Application by AQUIND Limited for an Order Granting Development Consent for the AQUIND Interconnector Project

Written Submission - Deadline-7 for 25th January 2021

APLEAL – Community Action Group

TITLE: **BROADWAY LANE SITE ACCESS JUNCTION - OPTION B GENERAL ARRANGEMENT**

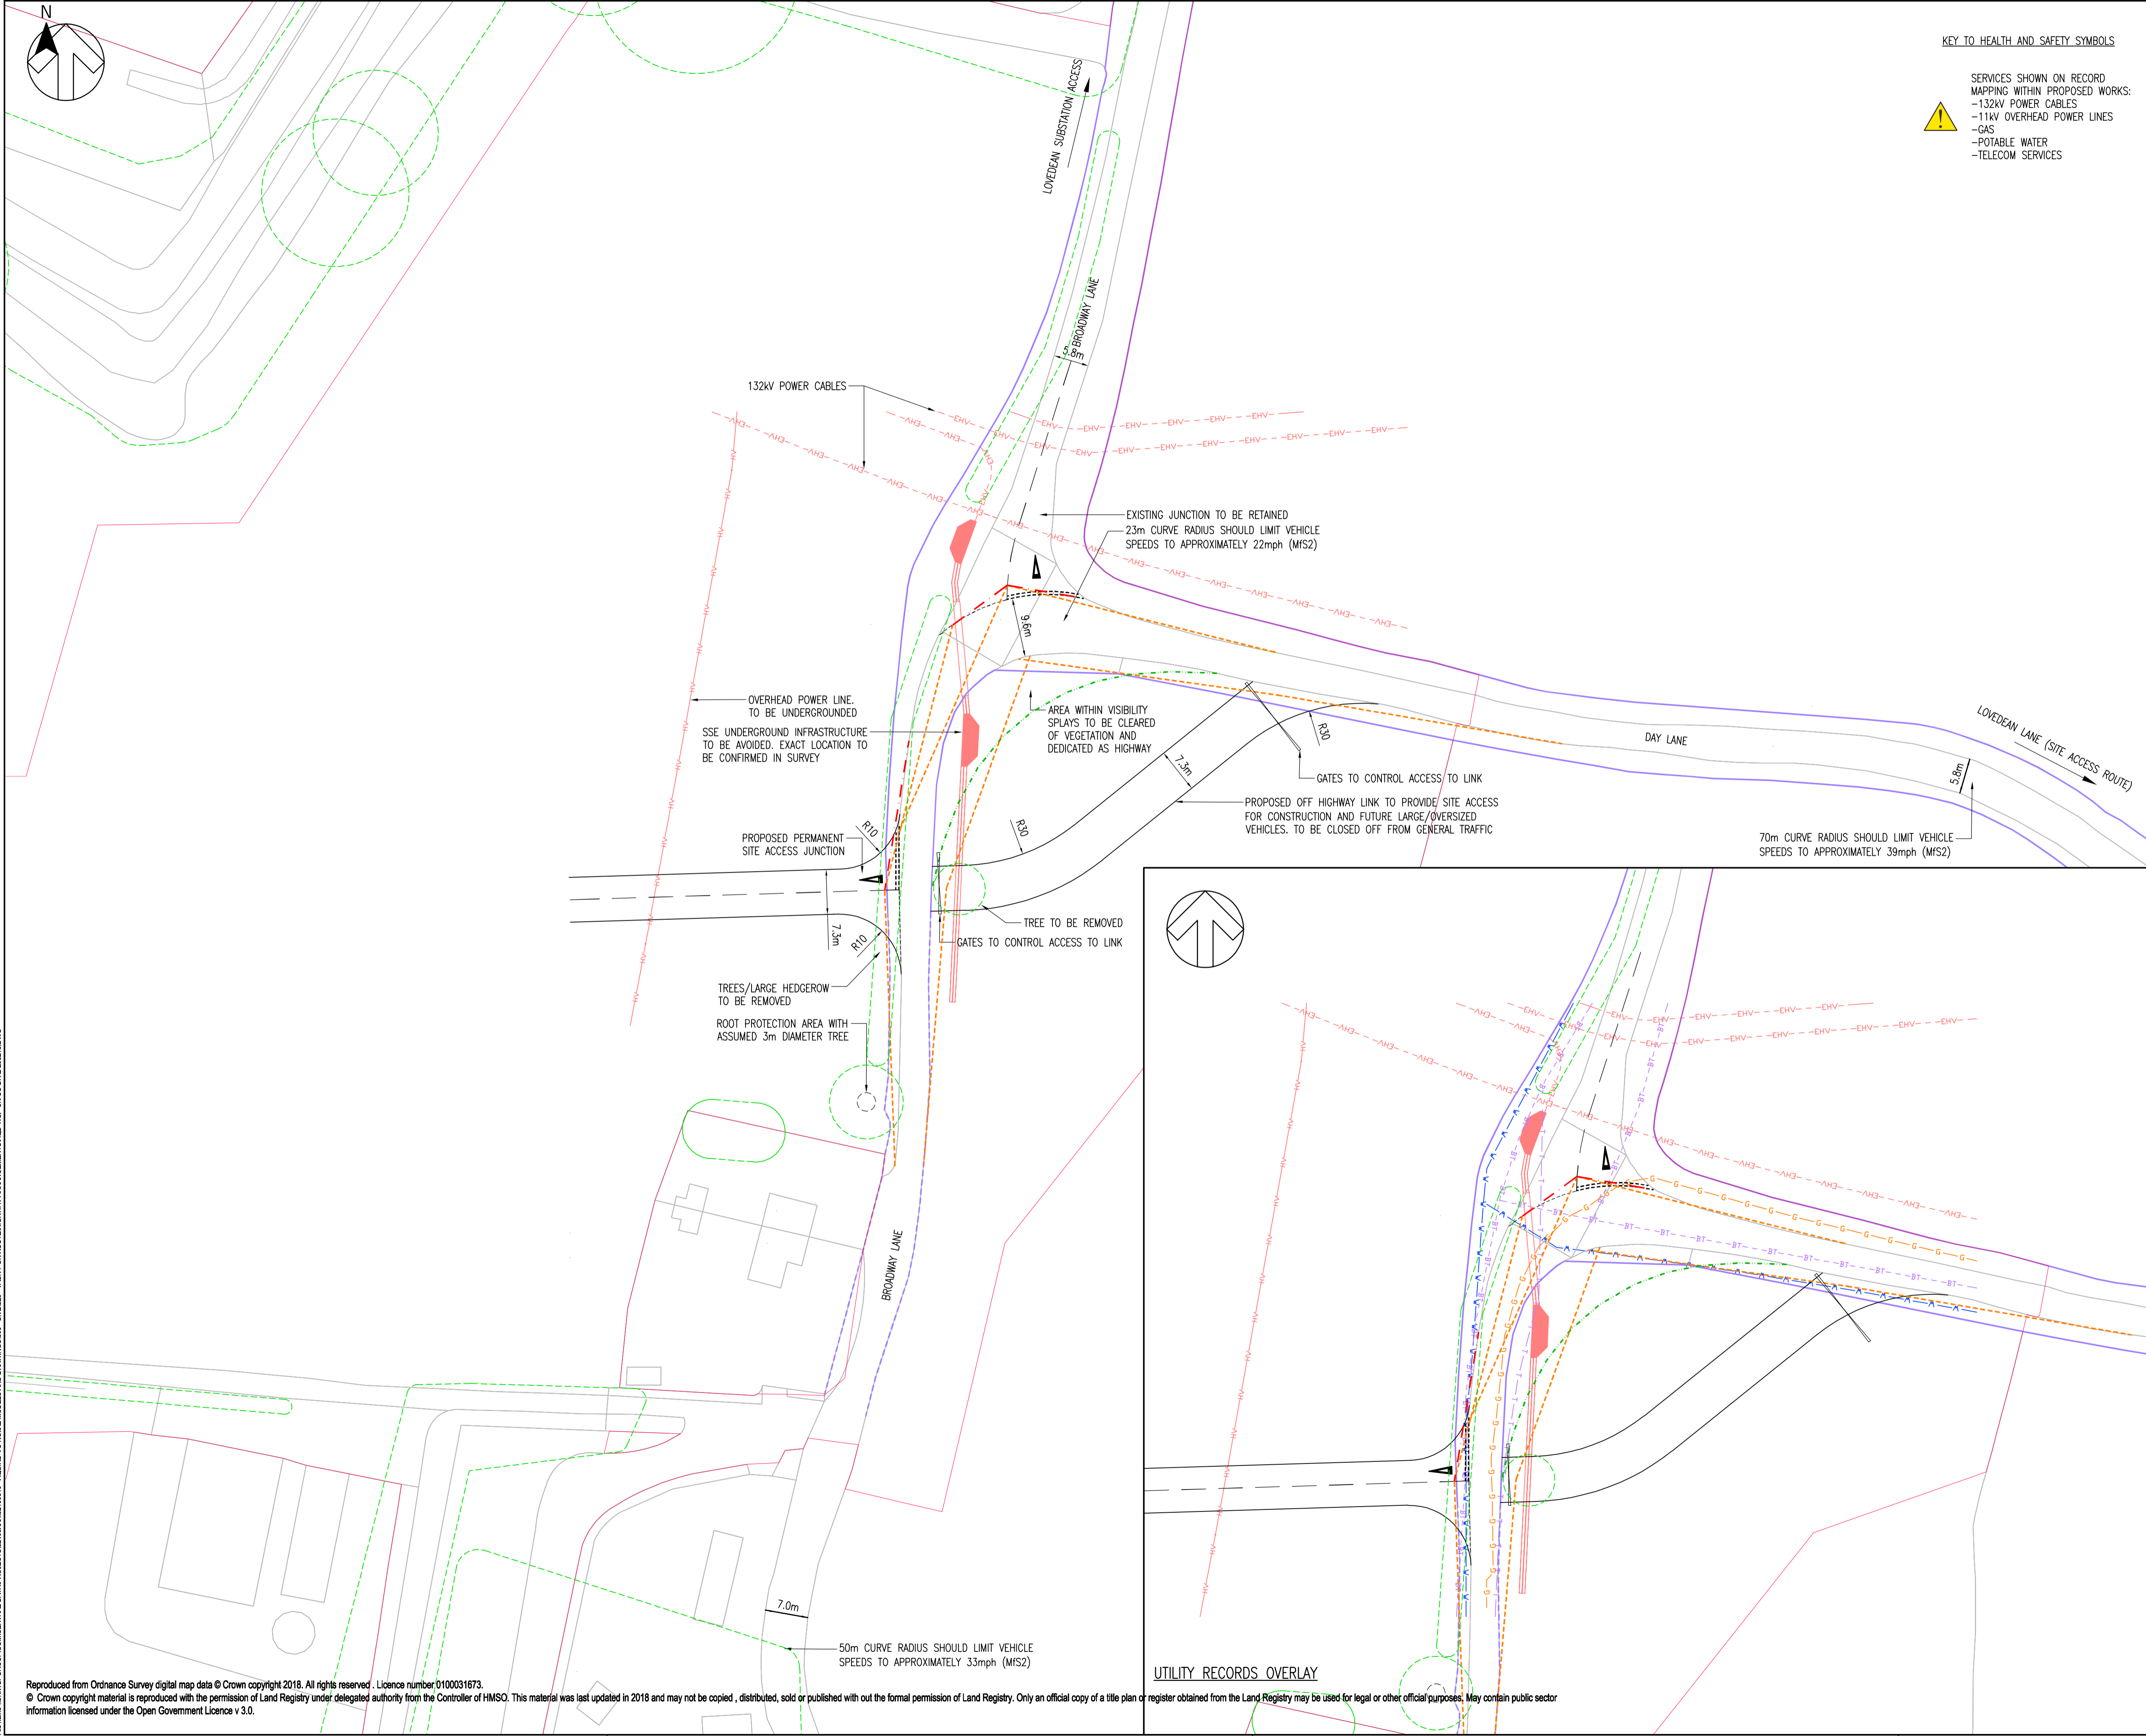
3. Temporary Site Access off Broadway Lane

APLEAL has been previously informed that some short-term use will be made of the existing farm track from Broadway Lane, which leads to the Lovedean Converter site. We are now informed that this could extend up to 12 months. This entrance off Broadway Lane is also, the residential access to numbers 1,2 and 3 Broadway Farm Barn, 2, Broadway Farm Cottage and Little Lovedean.

Having to share the residential property access with a stream of construction traffic is a considerable incumbrance on all the residents. Our strong recommendation is that this access off Broadway Lane should not be used and an alternative access sort.

Plate 6 - Proposed construction traffic management on Day Lane - will be replaced with full page image when issued as PDF

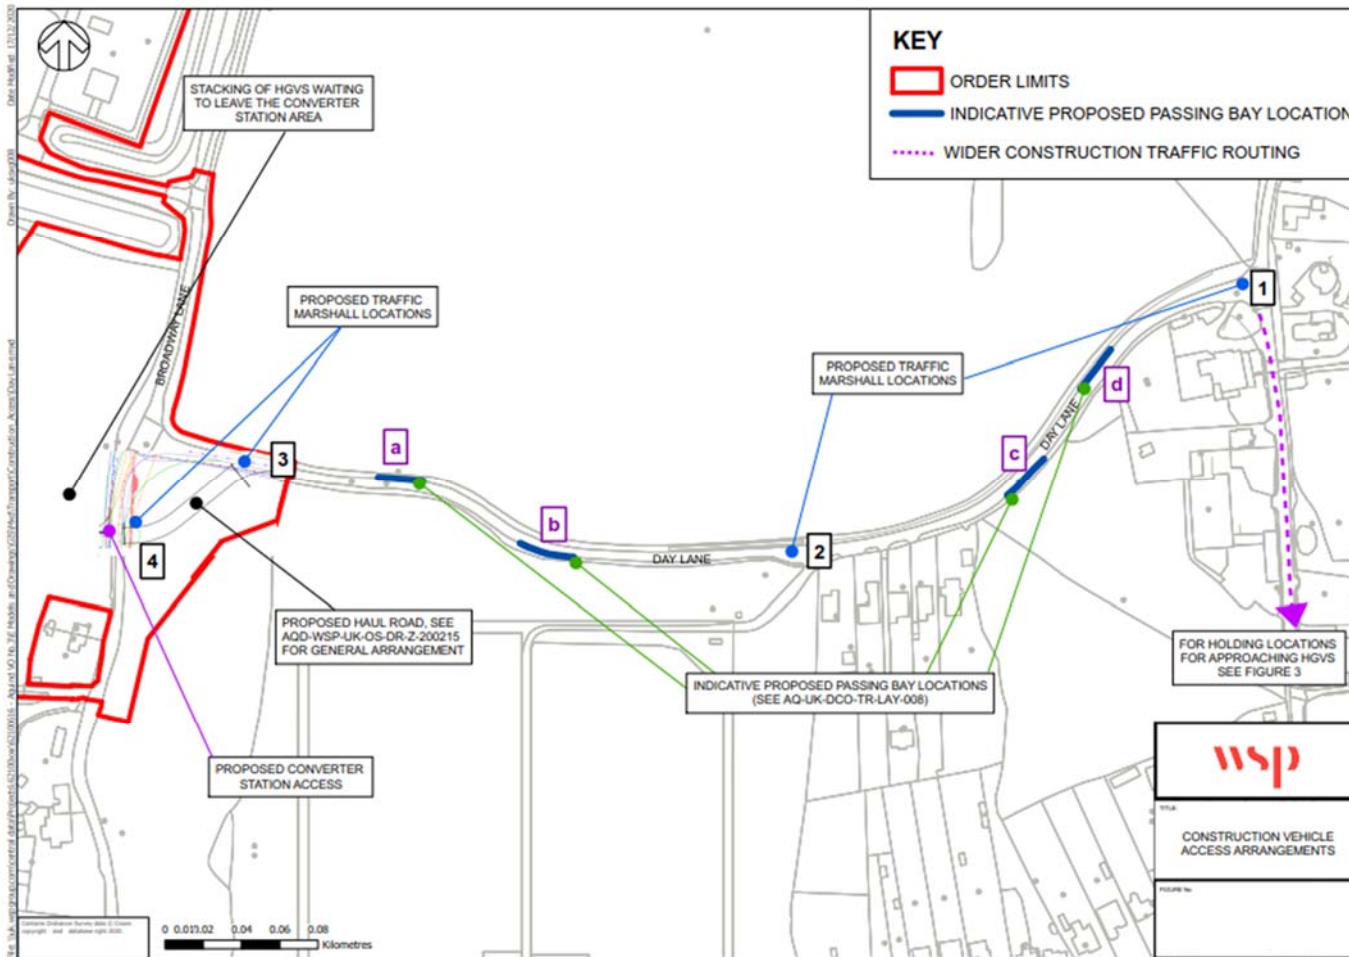
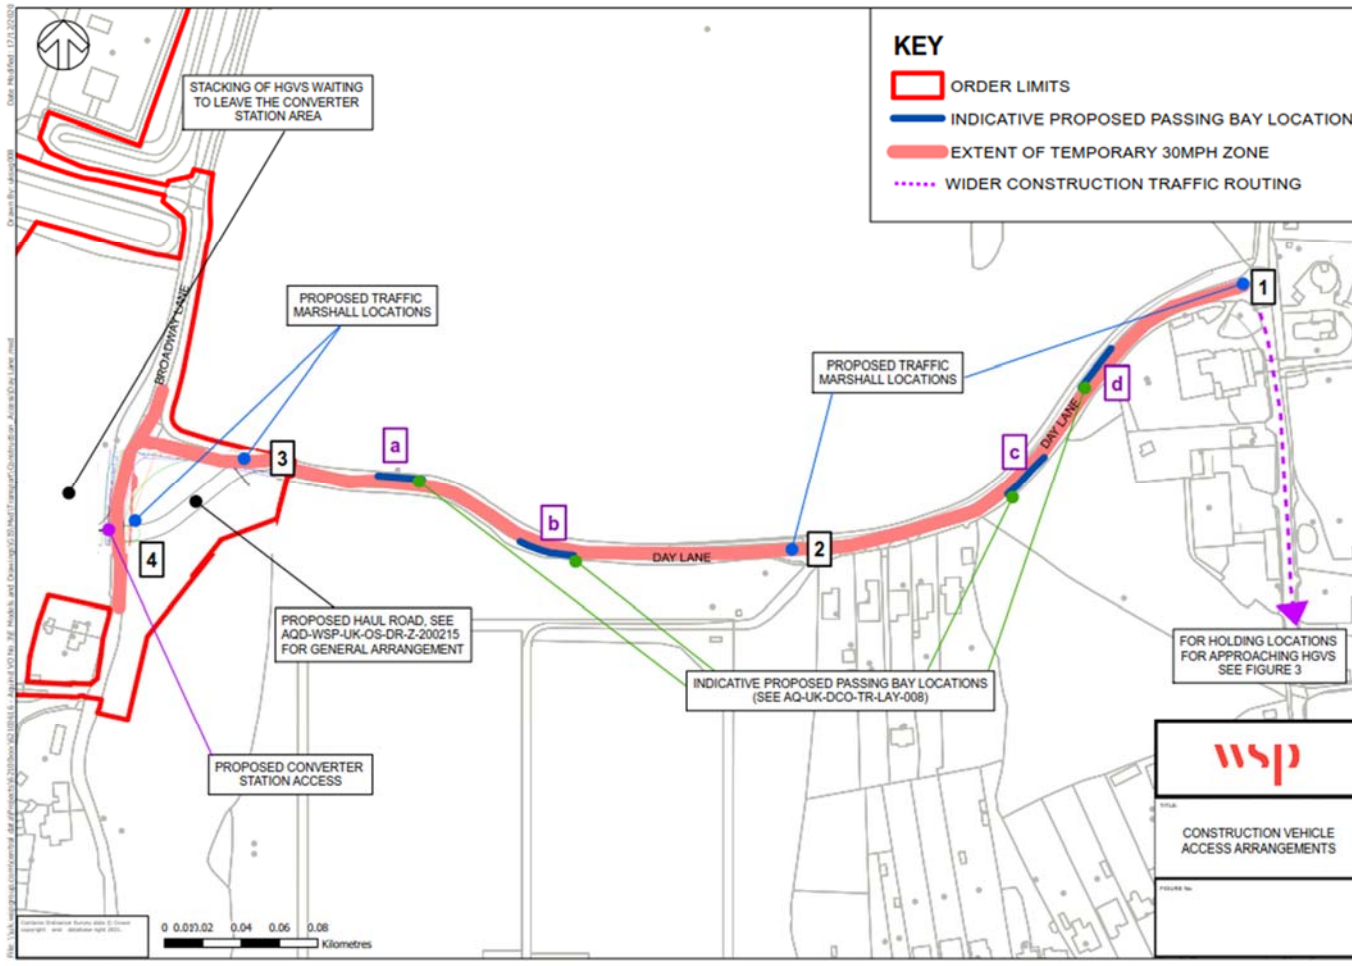
In our submission for Deadline 6 we raised our concerns about the safety of non-motorised users of Day Lane. Since then four passing places have been proposed in Day Lane. I have spoken with Hampshire CC Highways who inform me that these are necessary to ensure safe passing places for HGVs and cars. When I asked HCC Highways on their view about the safety of pedestrians, cyclists and horse riders in Day Lane the reply was the regulations did not require that provision be made for their safety. AQUIND have the opportunity to provide safe passage for these users by accessing the perimeter area of the Day Lane Solar Farm, this would involve very little cost. Especially considering that their plans include a slip road for large loads, which will cut across the perimeter land.

It would seem beyond the wit of any man that we see an issue regarding the safe passing of HGVs and cars, but have no issue with the safe passing of HGVs, cars and non-motorised users. If neither HCC Highways or AQUIND provide a rational case it is beholding that the Examining Authority to press the matter and /or explain themselves the reasoning?

Our issue here is that because nobody chooses to walk or cycle up or down Day Lane as it is not fit for any non-motorised users. Pedestrians, in particular, have minimal chance to escape oncoming vehicles. The photo below shows the situation at the top of Day Lane.

The fact that minimal pedestrian use is made of Day Lane will distort any statistics and hence the conclusion. The proposed work to include a special slip road for the transformers offers a great opportunity to improve safety for pedestrians and others and be of benefit to the wider community. The cost of this would be minimal, especially compared with the costs that may be incurred by the project as the result of an accident.

We ask that the applicant reviews the arrangements for all Road Users using Day Lane and the junction with Broadway Lane. Not just site traffic.
